From: Anita Gardner
Sent: 14 March 2017 11:44
To: Lisa Coney
Subject: FW: White Lodge Rectory Lane Angmering - A/207/16/HH and A/208/16/L

Subject: White Lodge Rectory Lane Angmering

drawing
Proposed Elevations

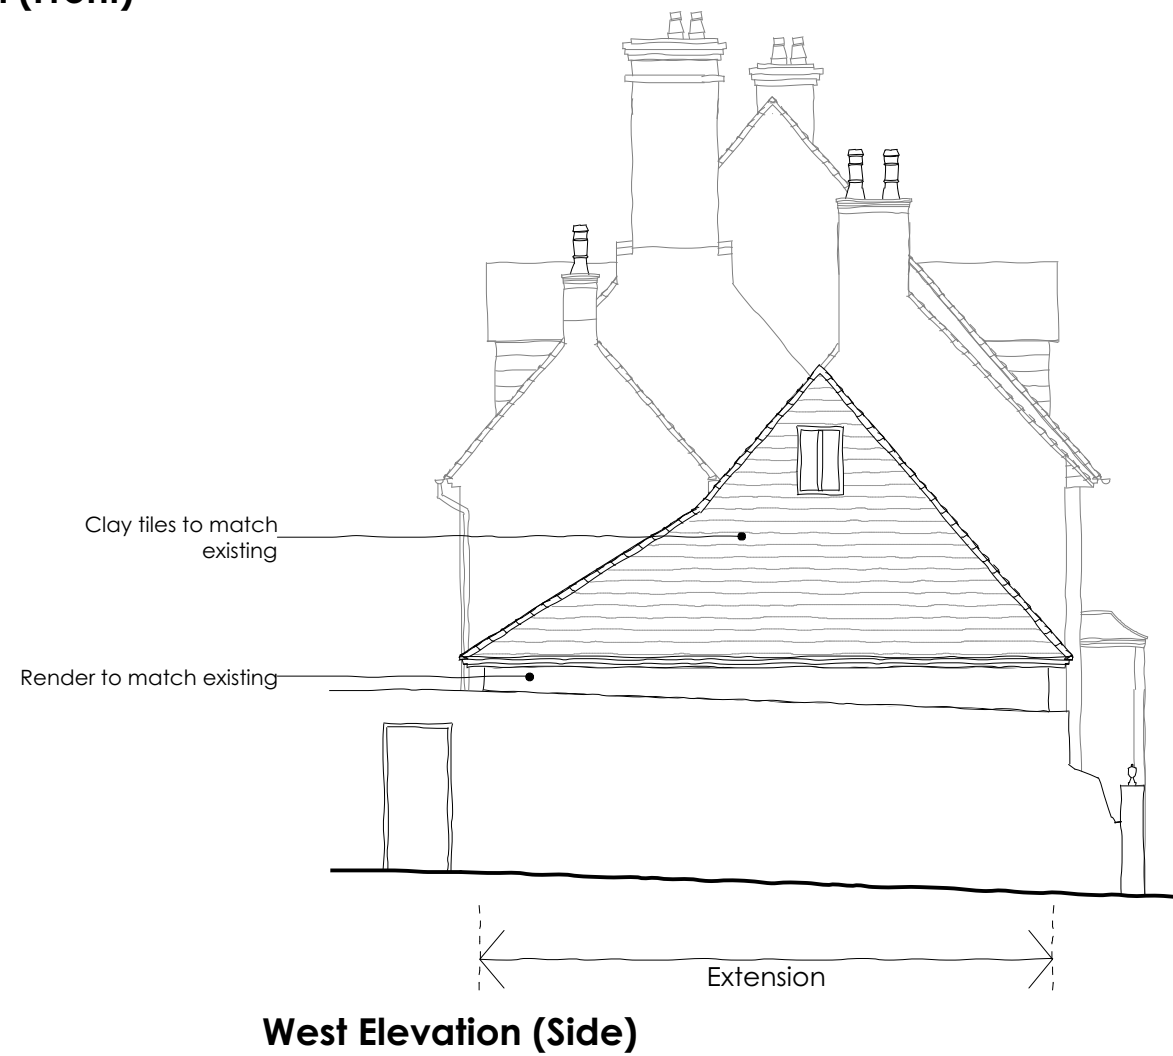
He has advised that he would be unlikely to support either proposal. The proportions and design of the single storey extension are considered inappropriate for the existing building they should be of a lighter construction and have a sloping roof to reflect the design of the opposite end of the dwelling and take the form of a glazed timber conservatory which is set in from both front and rear elevations. The opening up of the ground floor layout and complete removal of the end elevation of the property without retention of at least nibs would not be acceptable and would be deemed to adversely affect the character of the listed building.
